HUDSON MINOR SUBDIVISION Construction Drawings El Paso County, Colorado

GENERAL NOTES & LEGEND

PCD File No. MS-18-002

GENERAL NOTES & LEGEND

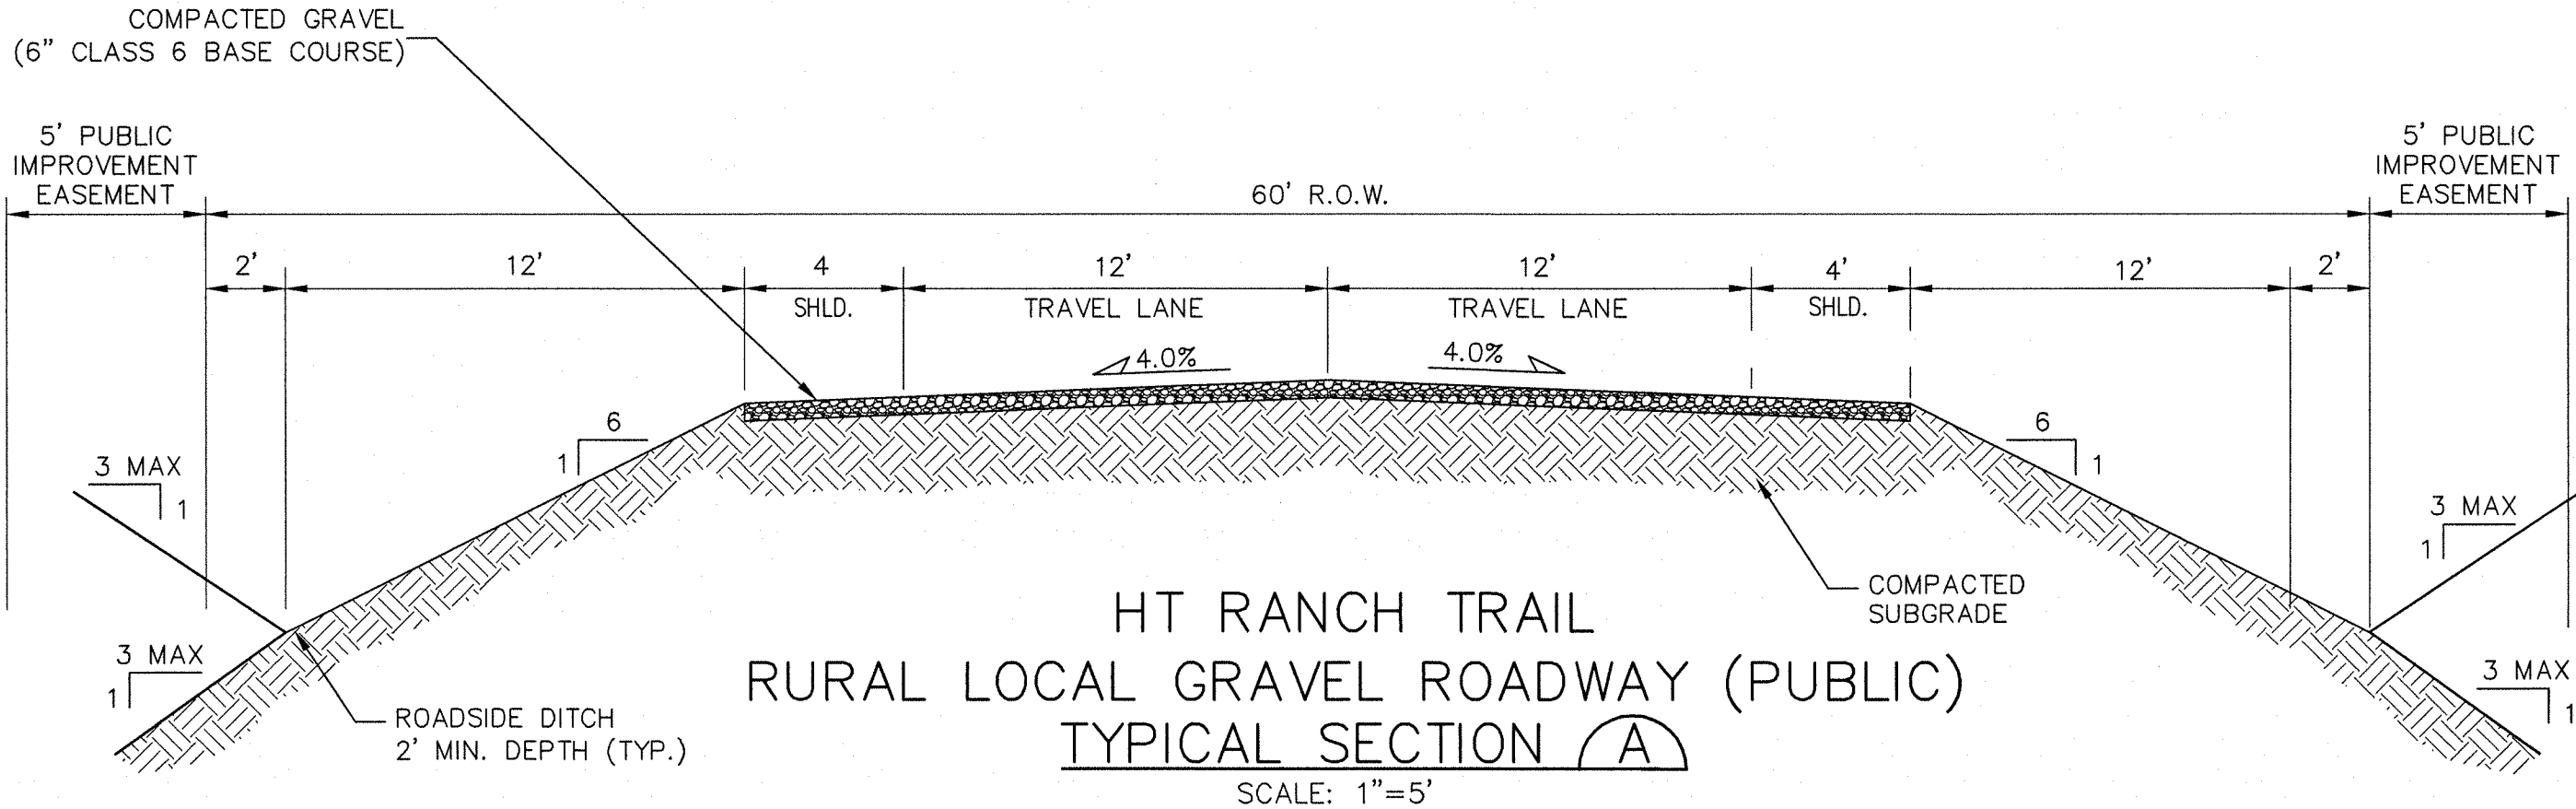
Fix design data text to its proper location

C2

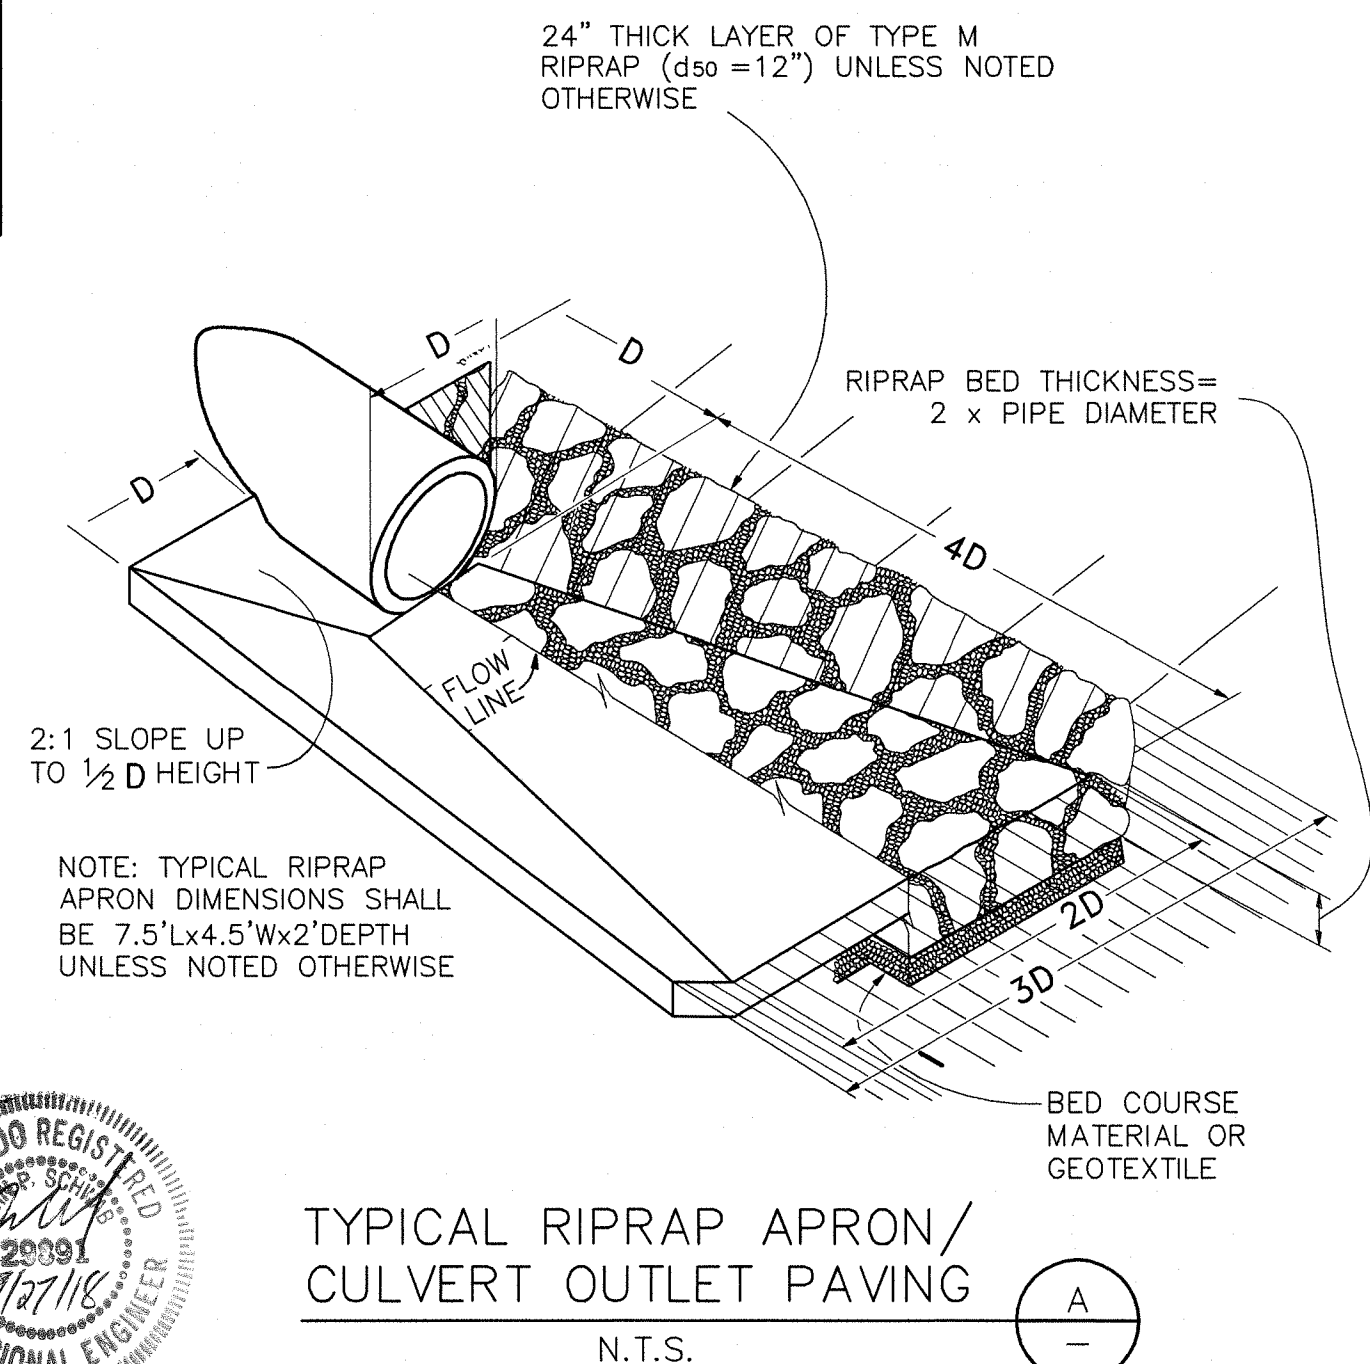
Update to reference the specific report.
